# Structural Integrity

April 10, 2013

Reference:  
RTU Replacement and Added Roof Insulation  
551 Congress Street  
Portland, Maine  
Structural Integrity Job: #13-0056

3 | ROOF SECTION  
SCALE: 1/4"=1'-0"

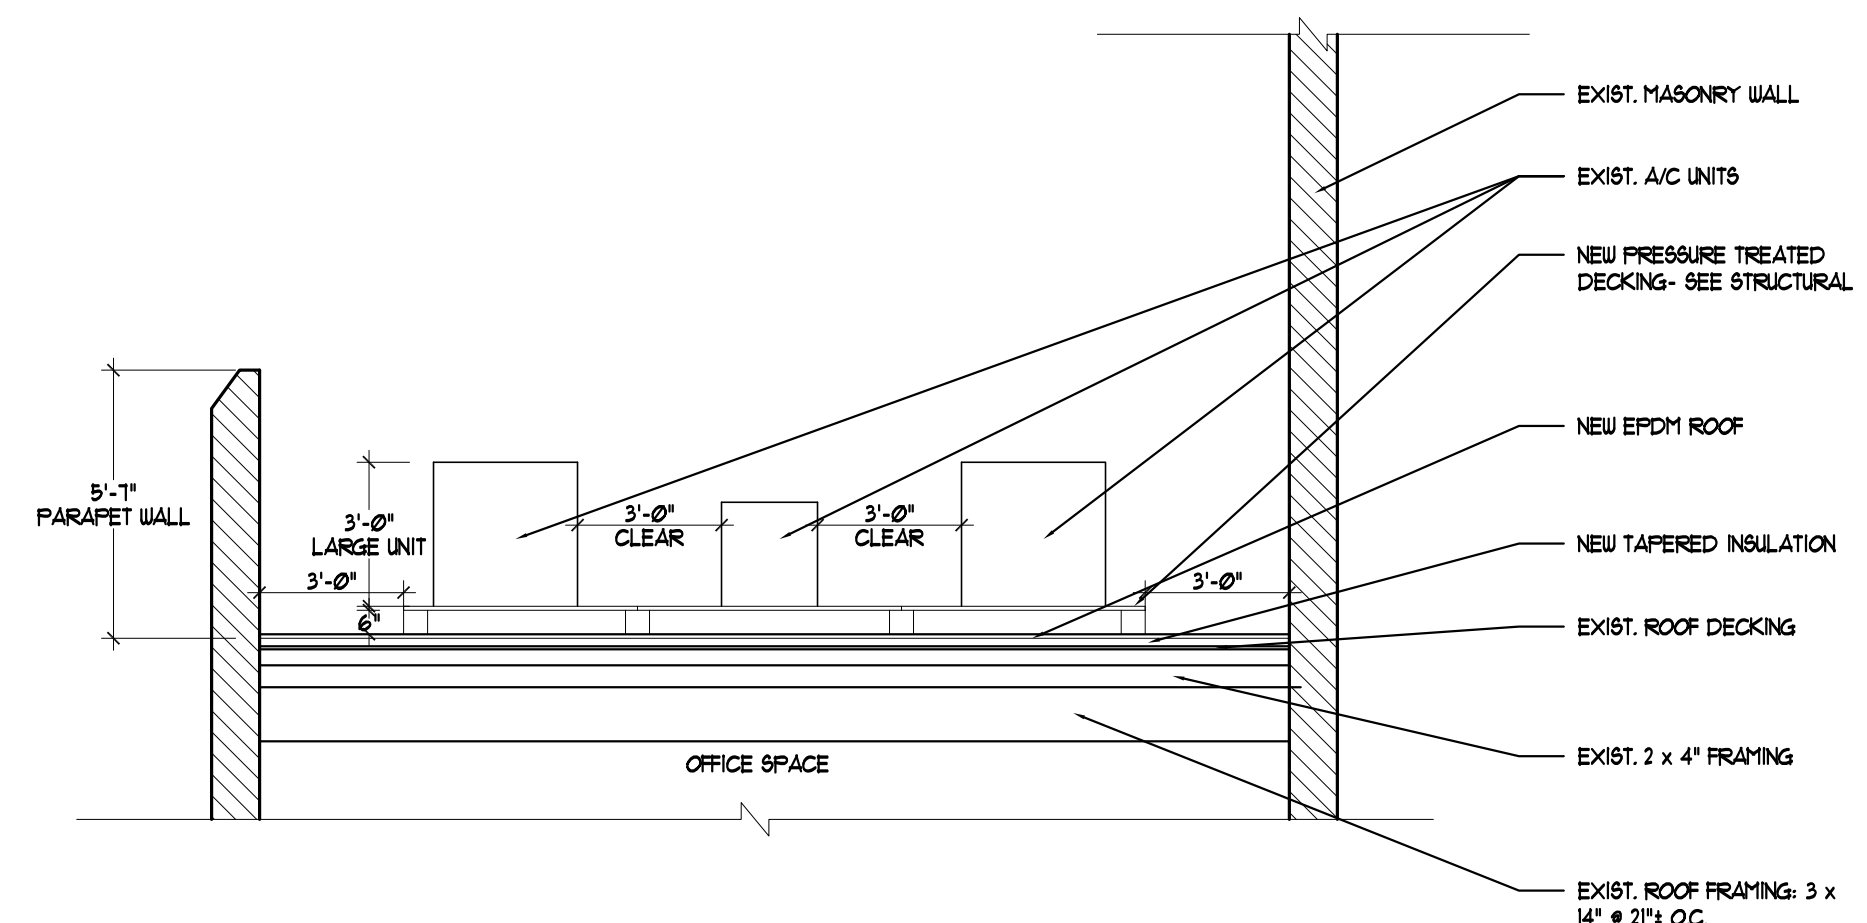
The existing roof is constructed with historic sawn rafters, 2 3/4" x 13 1/2" min. at up to 22" on center supported on pockets in the existing brick masonry walls. Based on my calculation I have found the existing rafters are suitable to support the code imposed loads with the following conditions:

1. The roof should be kept in service, as-is, without a hung ceiling.
2. It is also important that any insulation added as part of the re-roofing project be limited to an R-24 assembly, maximum.
3. New steel angle supports, L5x3 1/2" x 1/4" must be installed at the joist bearing along the Oak Street side of the building per the attached sketch, 1/S-2.
